**MOUNT OWEN CONTINUED OPERATIONS PROJECT – SSD 5850
RESPONSE TO SUBMISSIONS REPORT**

Reference is made to your email to the Environment Protection Authority (EPA), dated 6 August 2015, seeking comments from the EPA in regard to the Response to Submissions (RTS report) for the Mount Owen Continued Operations Project, SSD 5850.

EPA'S DETAILED AIR QUALITY RESPONSE TO SUBMISSION COMMENTS MOUNT OWEN CONTINUED OPERATIONS PROJECT, SSD 5850

FIGURE 4.2

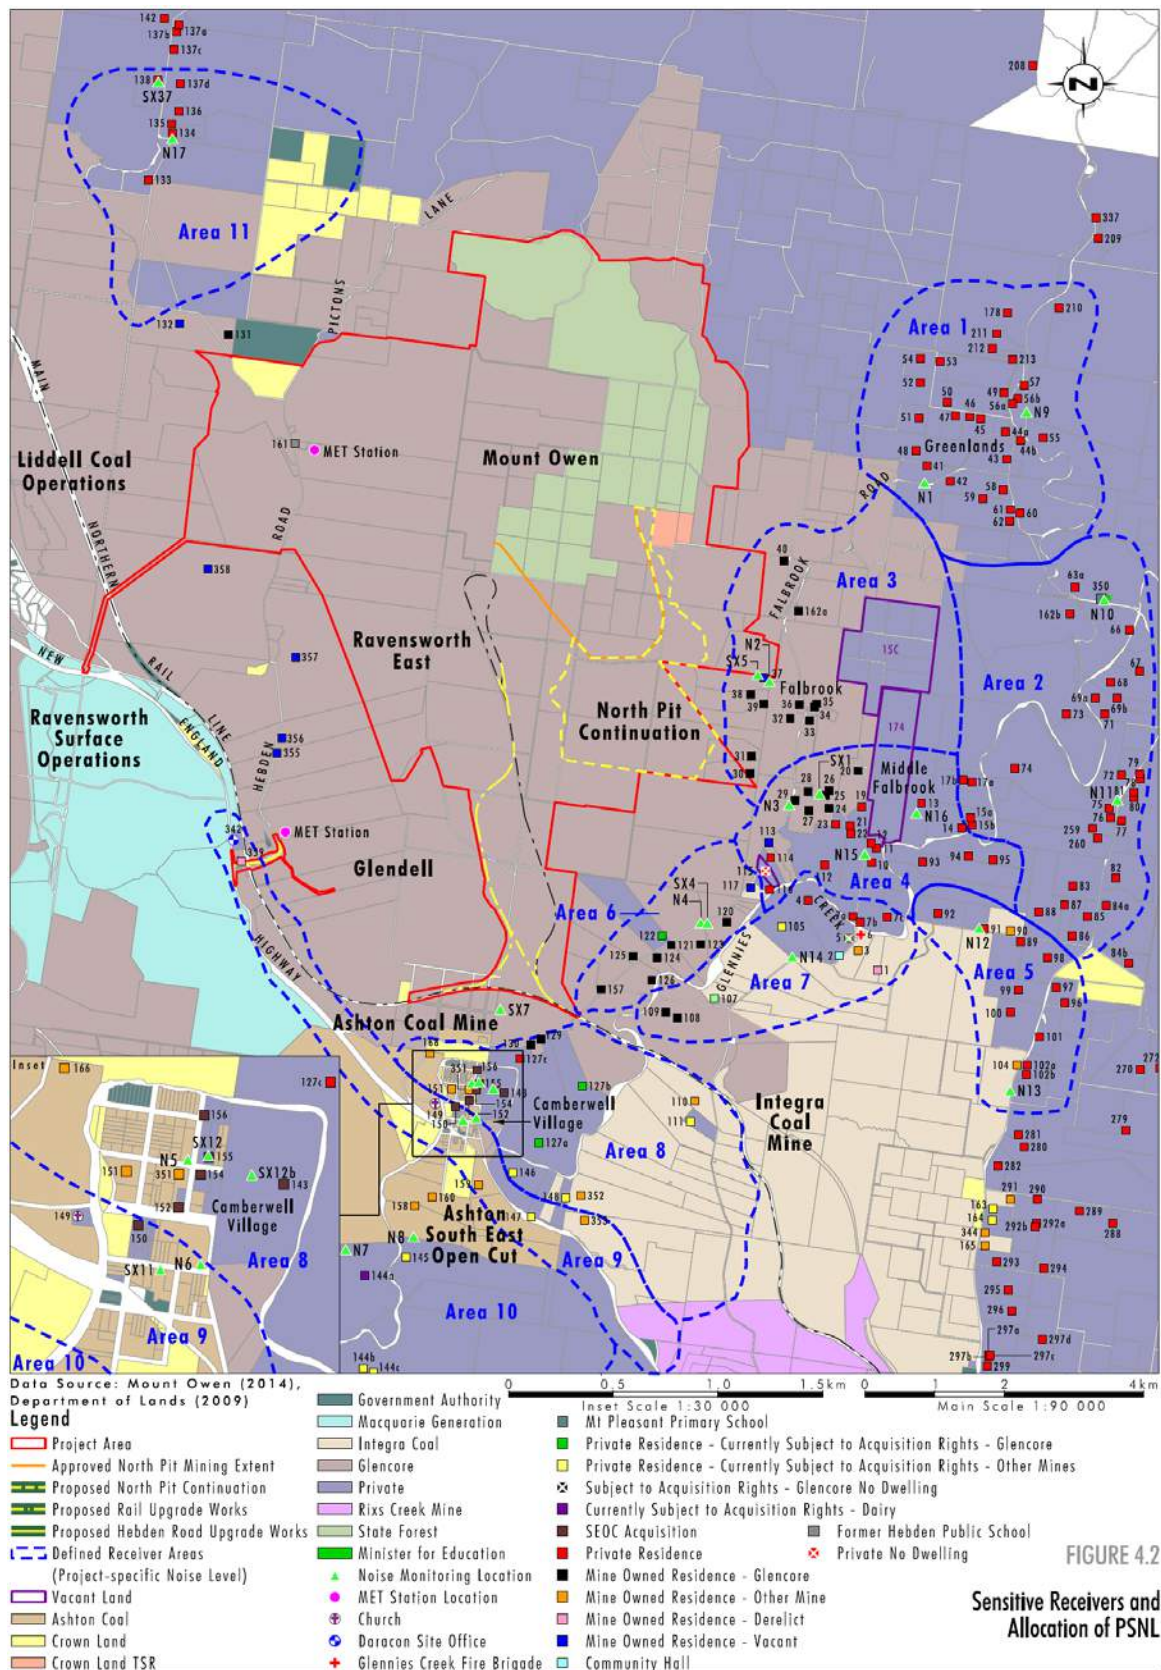
Table 6.1 of the NIA appears to show a number of sites that will have operational noise levels ≥ 5 dB above the project specific noise level. For example, sites R021, R022, R023 and R093 within Area 4 shown in Figure 4.2 of the NIA.

As previously noted, where noise levels are predicted to be above the project specific noise levels determined for a project, the Department of Planning and Environment is best positioned to review the benefits of the proposal against the potential adverse noise impacts and determine if noise limits above the project specific noise levels are justified.
